**KIRKLEES COUNCIL
TOWN AND COUNTRY PLANNING ACT 1990
HIGHWAYS DEVELOPMENT MANAGEMENT**

PLANNING REF 2018/62/92216/W0/NH
CATEGORY Small Major

PROPOSAL ERECTION OF 5 DWELLINGS

LOCATION LAND OFF, NETHERLEY DRIVE,
MARSDEN,
HUDDERSFIELD,
HD7 6HL

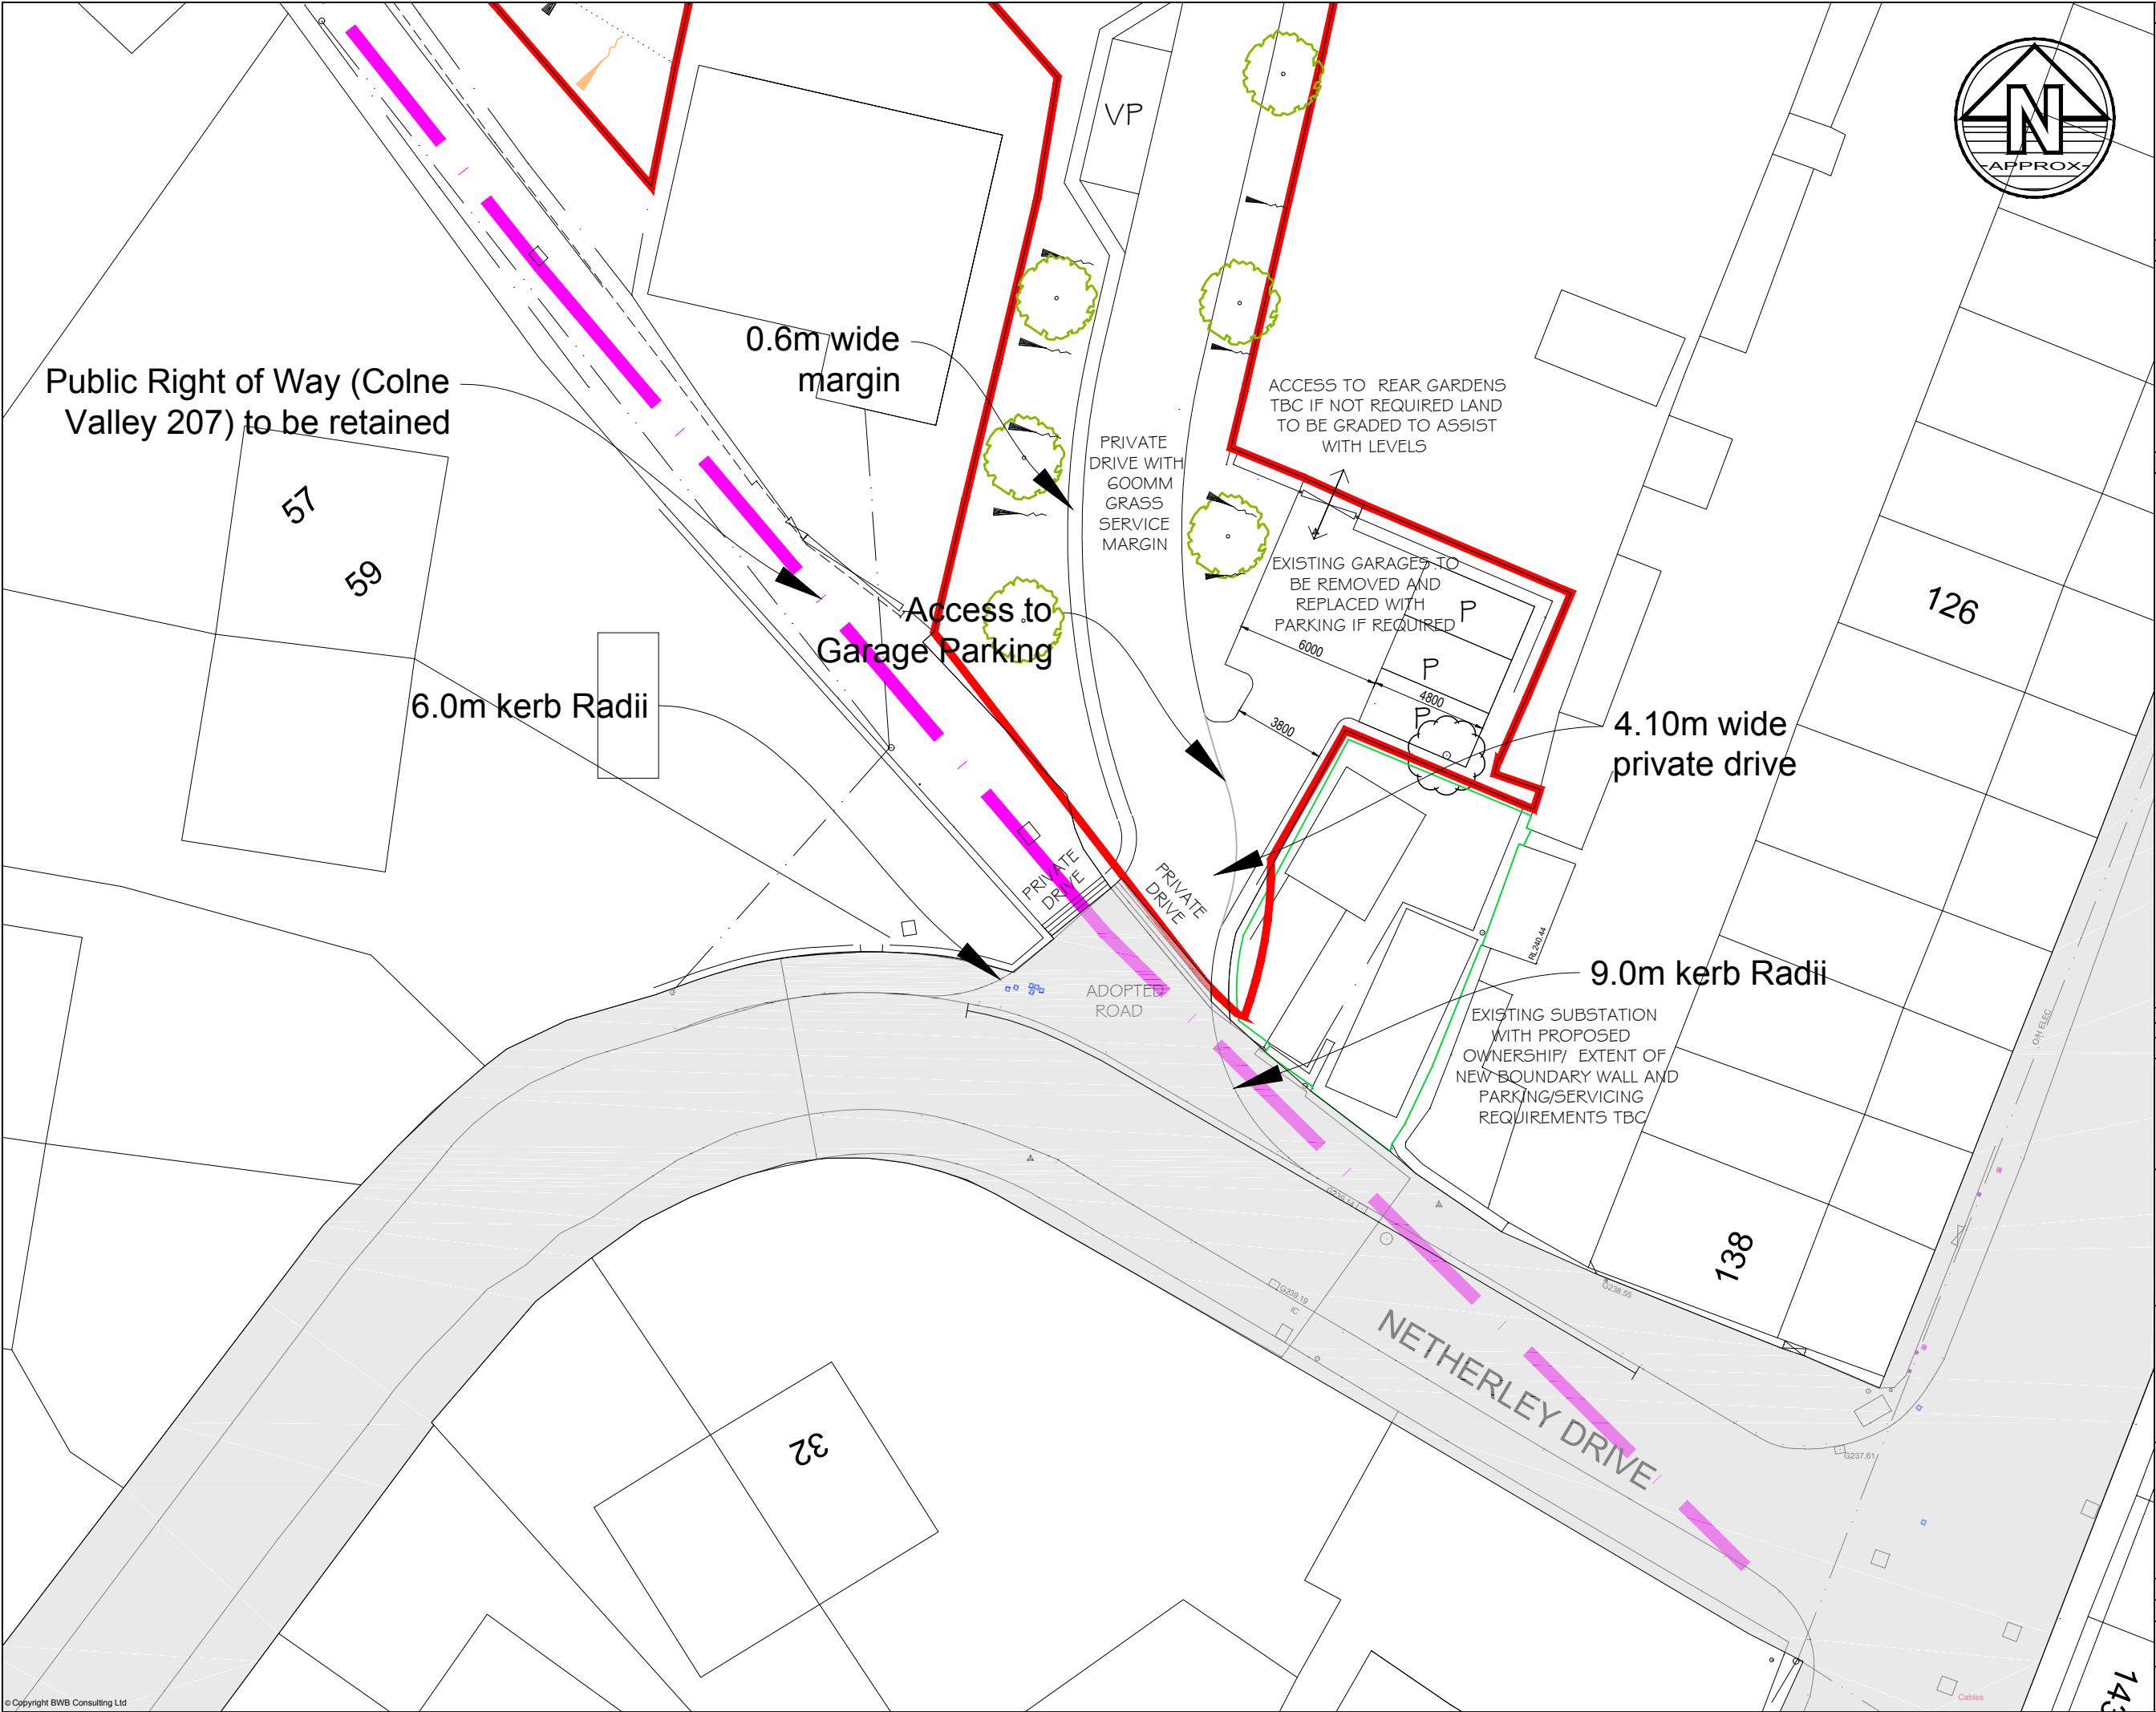
The application has provided a swept path analysis for both the access and a proposed turning head at the end of the private driveway, however this has been done using a 10.59m vehicle and this is not suitable as Kirklees cleansing guidance requests the use of an 11.85m refuse vehicle. The swept path analysis should be re-done to show that the larger refuse vehicle can access and turn within the site for road safety reasons. Again, if you are minded for approval we request that this is added as a condition.

DRAWING NUMBER:
P18 5153 02

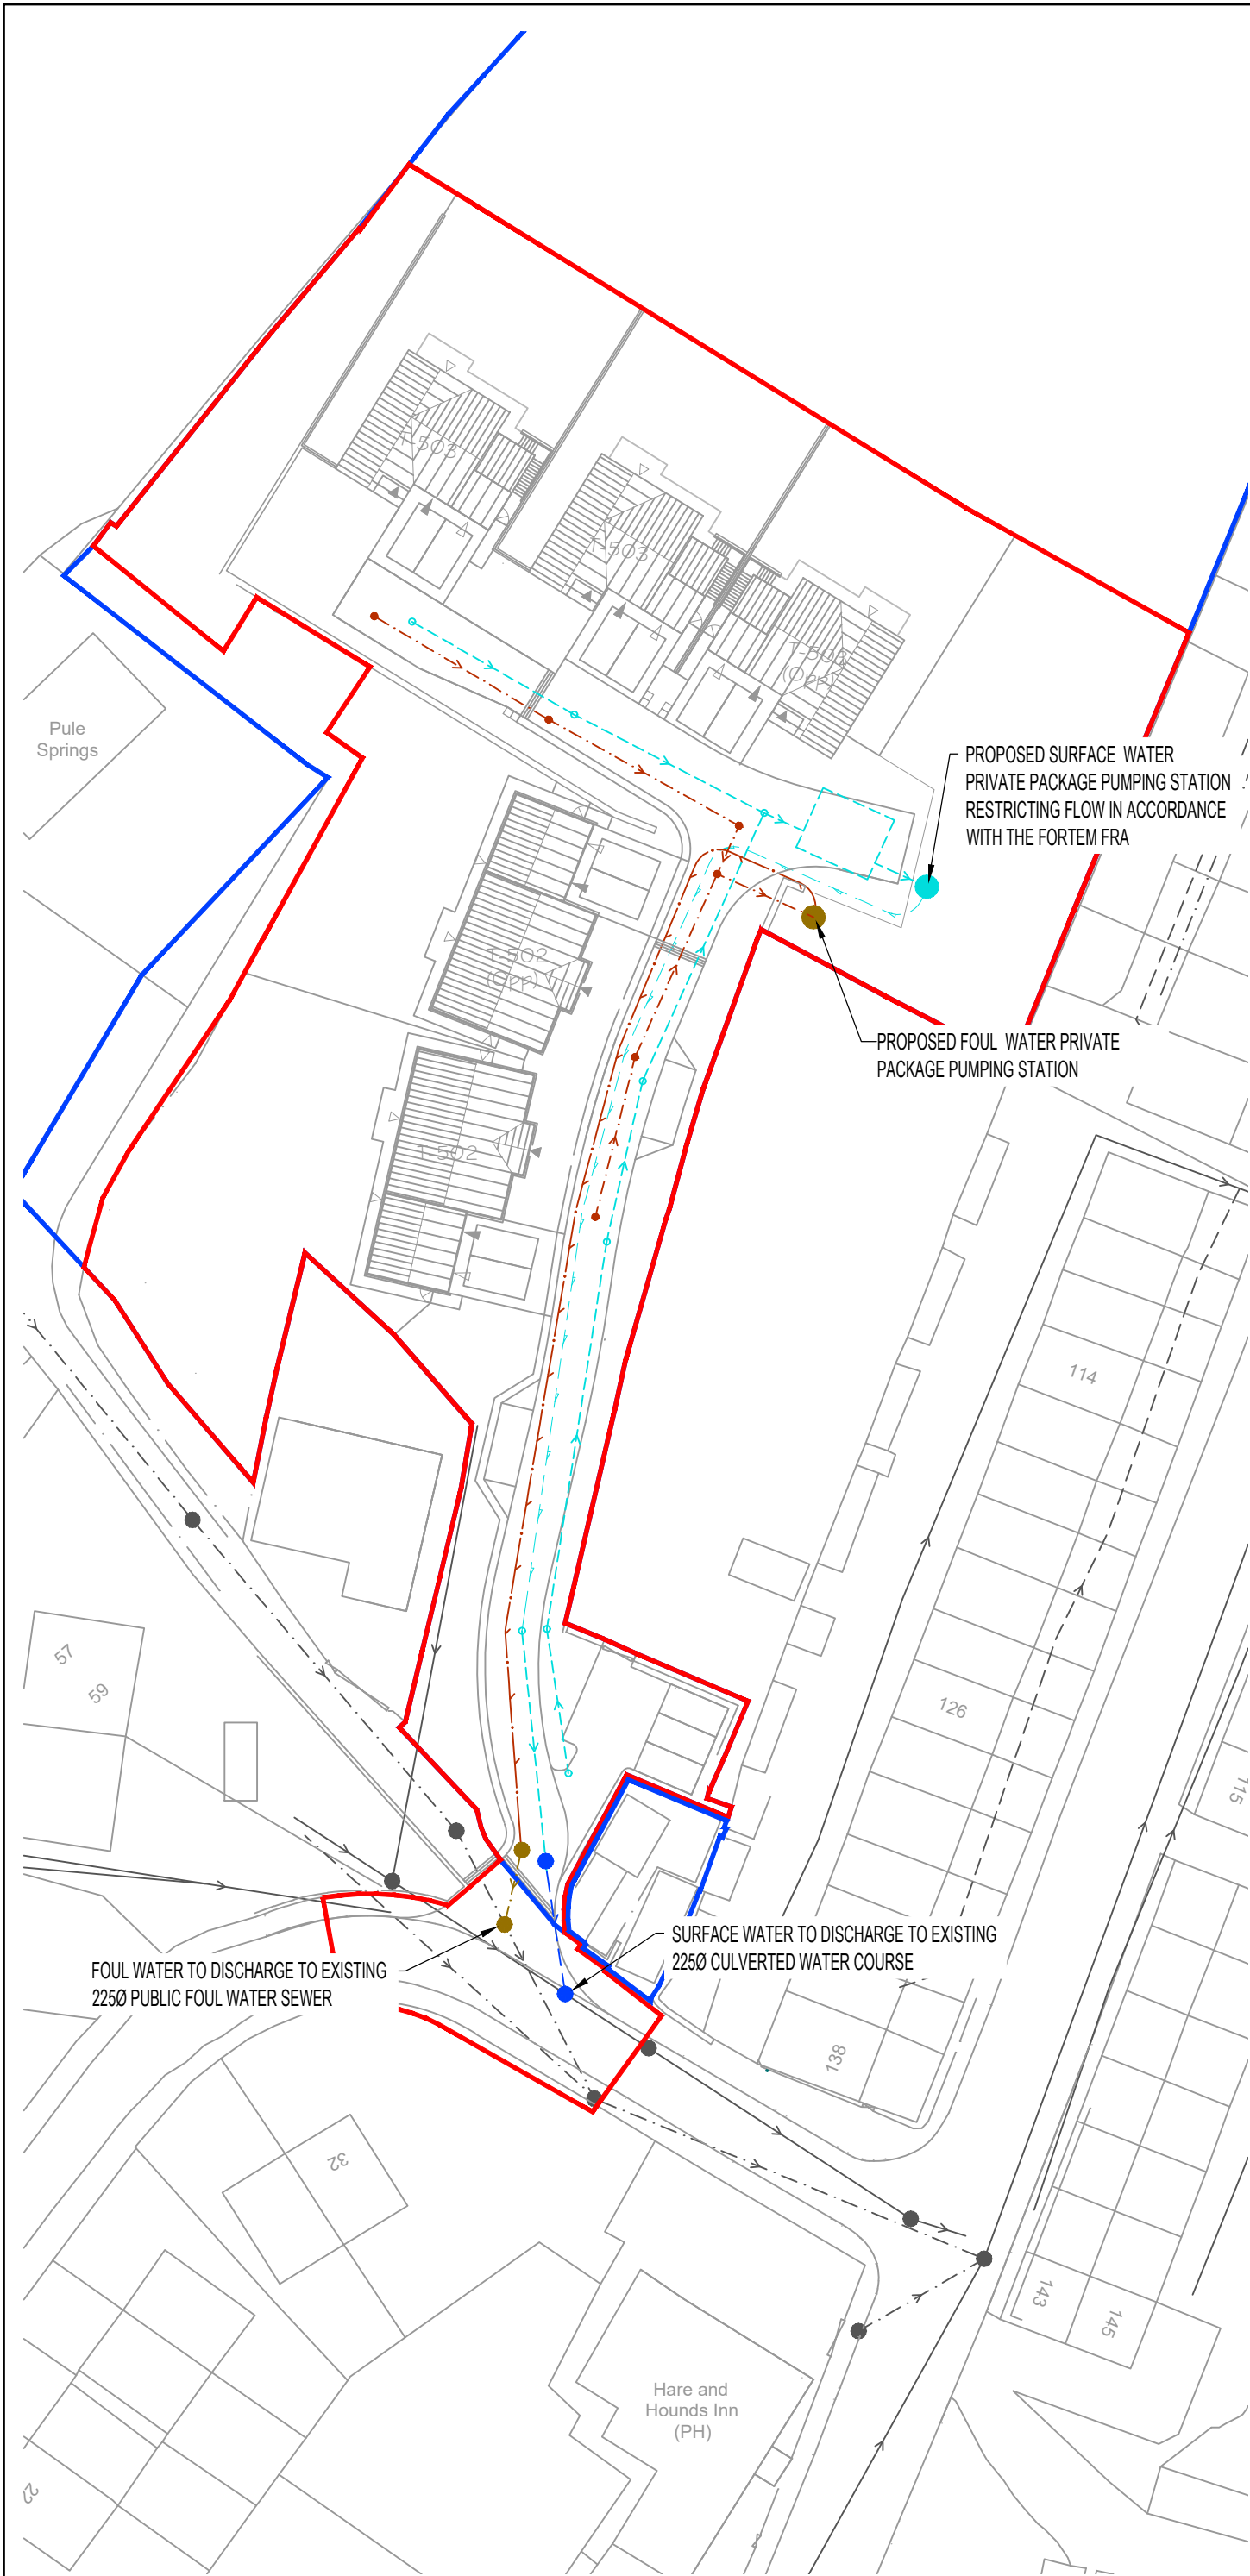
The grouped plans and elevation drawings (18 5153 05 and 18 5153 06) show that the integral garages and car ports are suitable for two vehicles and proposed site layout drawing (P18 5153 02) indicates that there are external parking spaces for two further vehicles, there are also two shared visitor parking spaces on the private drive. This number of spaces accords with Kirklees parking standards.

The number and location of refuse/recycling bin collection points shown on drawing P18 5153 02 is acceptable as they are all within recommended carry distances, are accessible for cleansing operatives and do not obstruct the highway or footway.
